**STONE COLLAR DETAILS ⑥**  
SCALE: 3/8" = 1'-0"

Addendum #2		ESC	05/19/10
NO.	REVISION	BY	DATE
<b>TOWN OF ADDISON</b> DALLAS COUNTY, TEXAS			
<b>VITRUVIAN PARK BRIDGES</b> PONTE AVENUE			
<b>MISCELLANEOUS DETAILS</b>			
<b>HALFF</b> 1201 NORTH BOWSER ROAD, RICHARDSON, TEXAS 75081-2275 TEL (214) 348-0200 FAX (214) 730-0066			
PROJECT	DESIGN	DRAWN	DATE
27379	ESC	AHH	APRIL 2010
			FILE
			SHEET
			S1-18

PRECAST LEDGE DETAIL

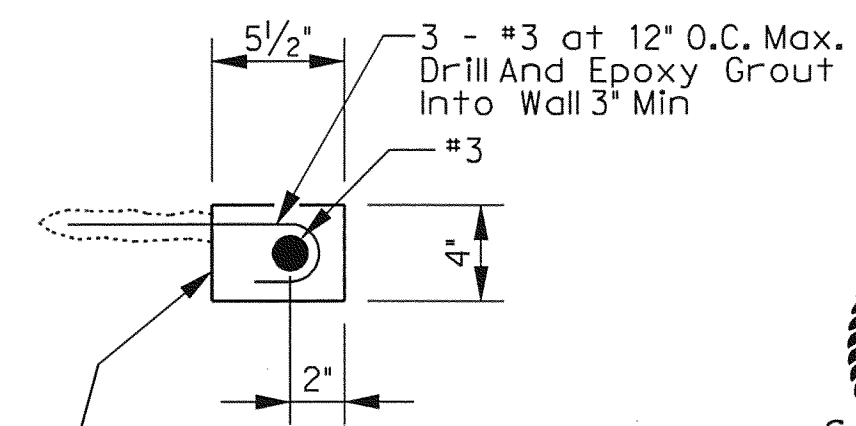
- ⑥ For Abutment details and bar details not shown, see Drawing Nos. S1-05 to S1-14.
- ⑦ Prior to Arch installation a temporary stone support (L5 x 3 x 1/4 (LLV)) shall be used. Installation with three 1/2 inch Hilti Quik Bolt 3 expansion anchors embedded 3 1/2 inches min. Coordinate removal of stone veneer and temporary stone support with steel arch erector. Replace the temporary stone ledge with precast ledge after arch has been installed. At the Contractor's option, the stone veneer may be installed after the Arch is fully erected. If this option is used, the temporary stone support (L5 x 3 x 1/4) is not needed. For either option, the precast ledge shall be installed only after the Arch is fully erected.
